CITY OF ALBUQUERQUE

**RE: Cleveland Middle School Track and Field
6910 Natalie Ave NE
Grading and Drainage Plan
Engineer's Stamp Date 2/6/2017 (File: G18D036)**

Based upon the information provided in your submittal received 2/6/17 and updated information provided on 3/9/17, the Grading and Drainage Plan is approved for Grading Permit and Paving Permit with the following recommendations:

GRADING PLAN
TRACK AND FIELD IMPROVEMENTS
CLEVELAND MIDDLE SCHOOL
6910 NATALIE AVENUE N.E.

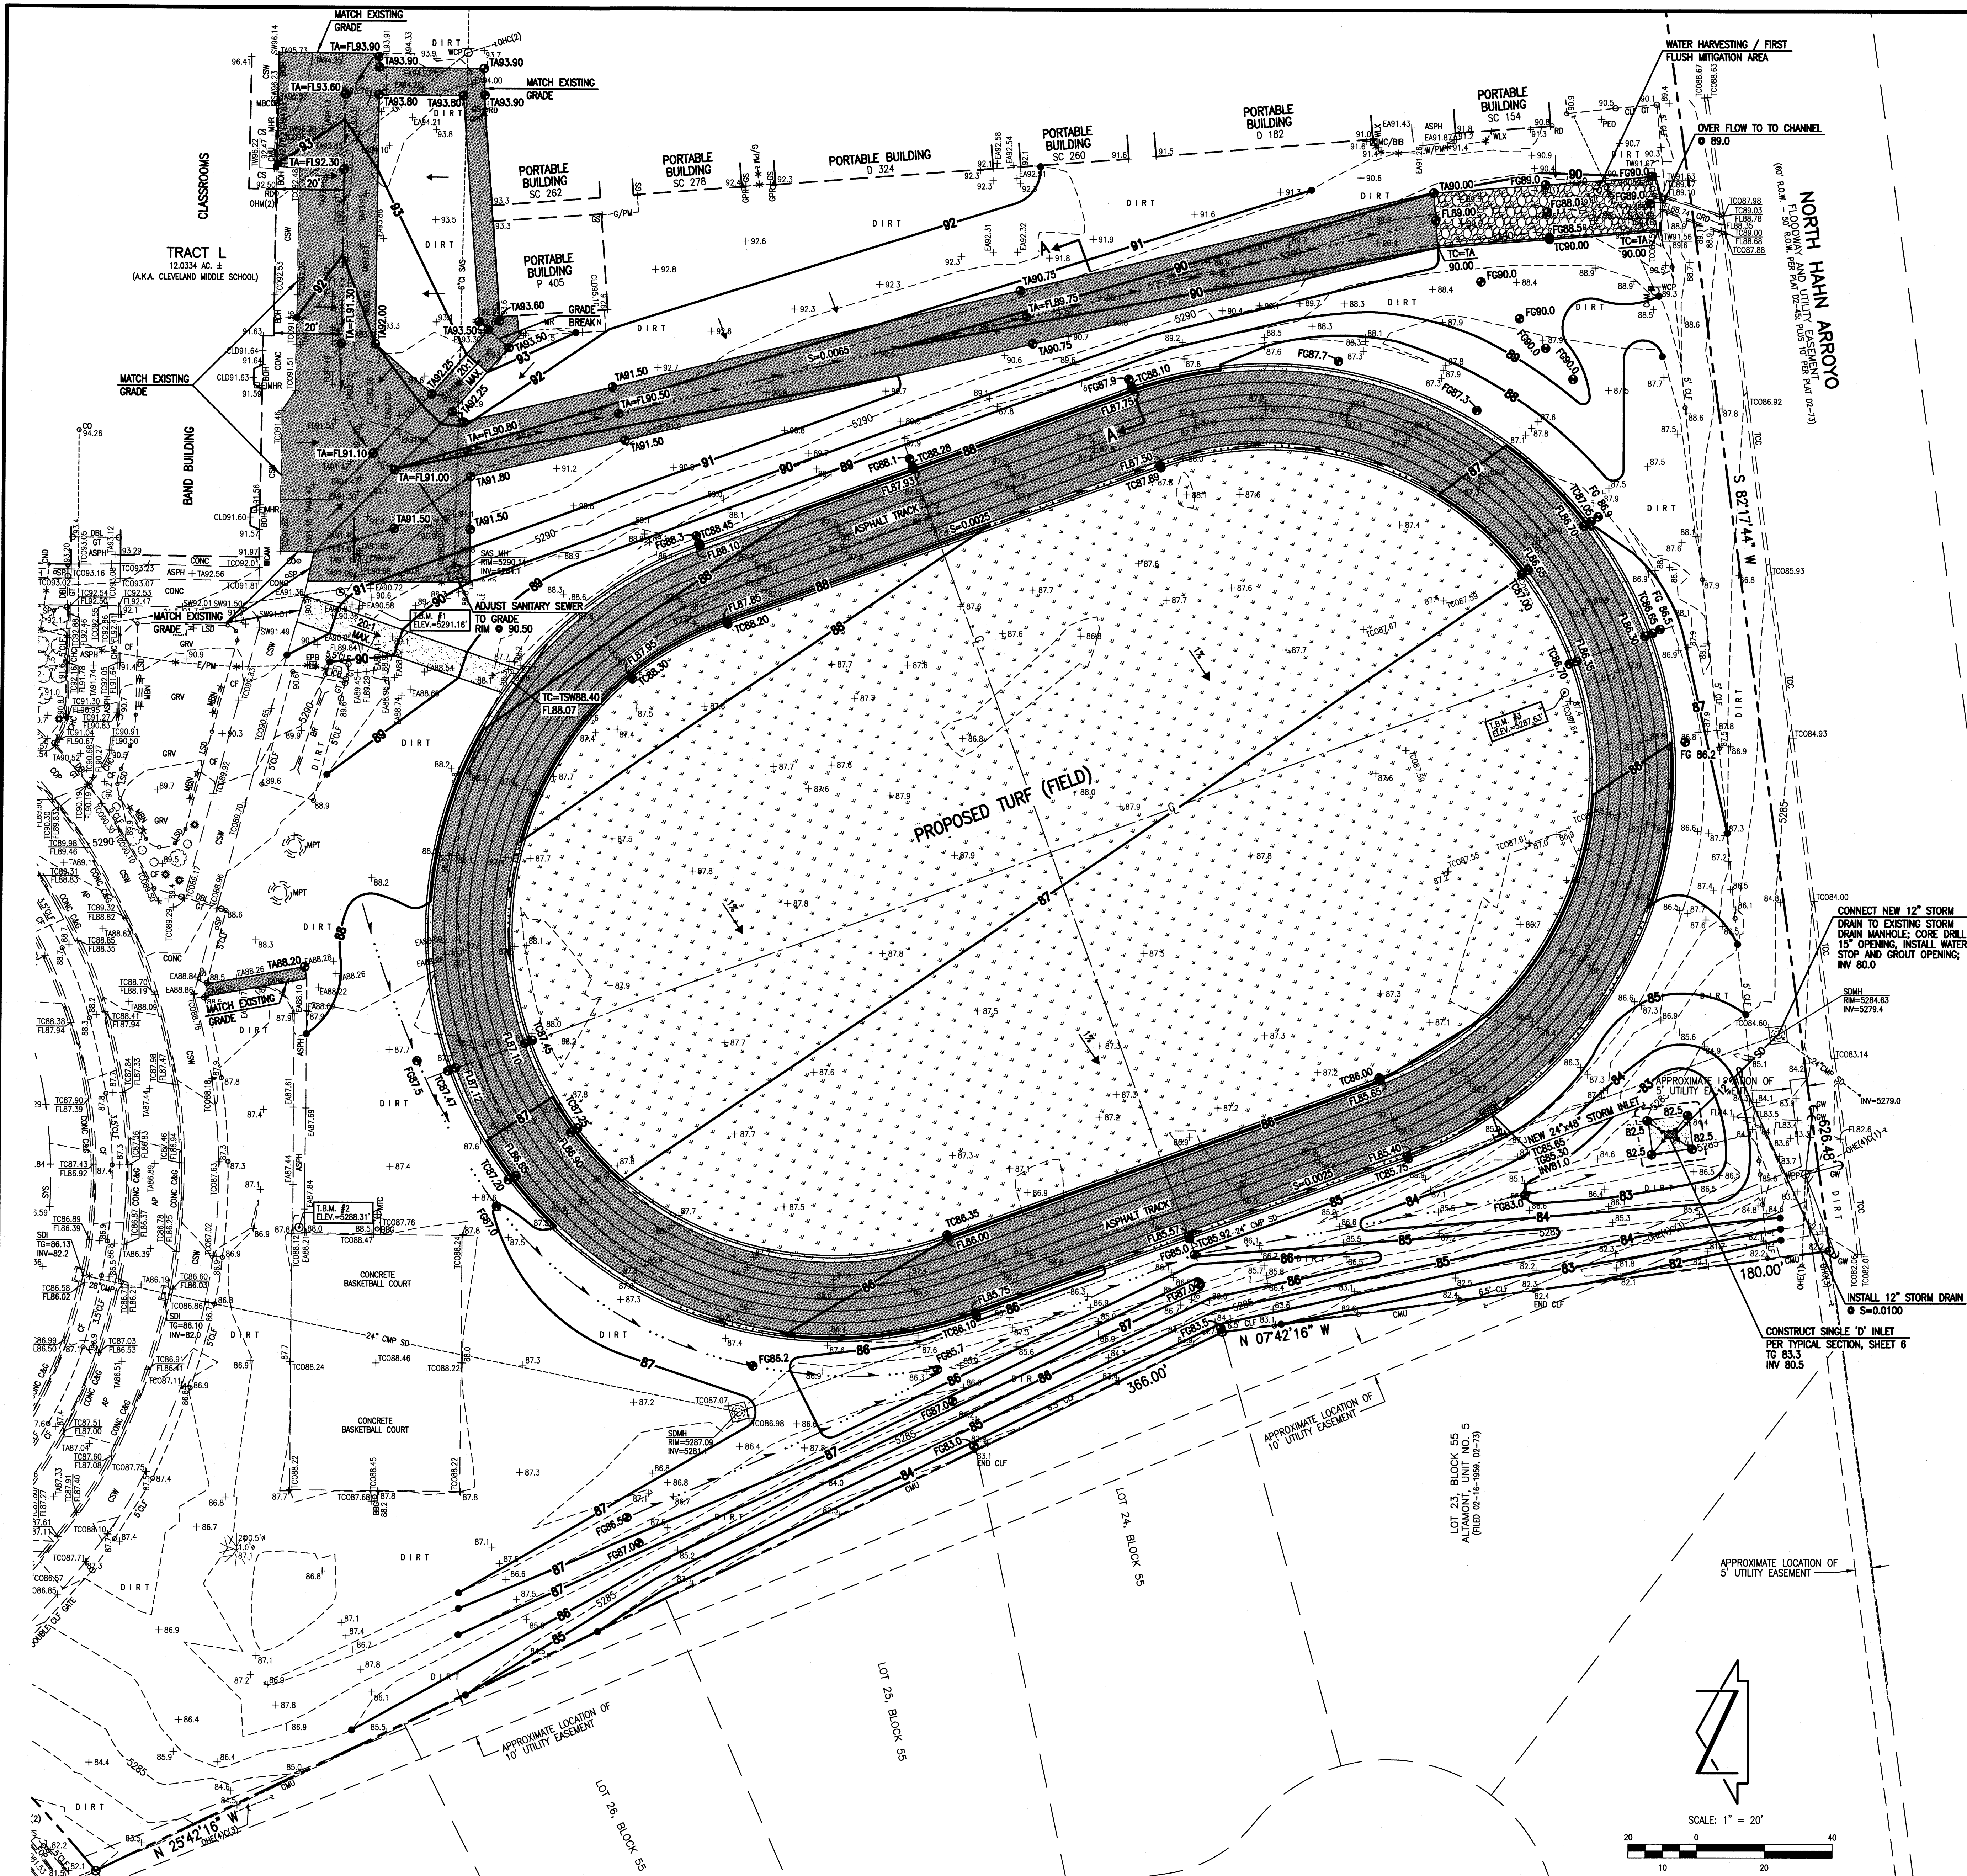
1. Provide an alley gutter for the paved drainage-way between the portable buildings and the track to prevent early failure of the pavement.
2. On Sheet 2, Section C-2, reduce the slope to 0% adjacent to back of curb to keep sediment from washing onto the track.
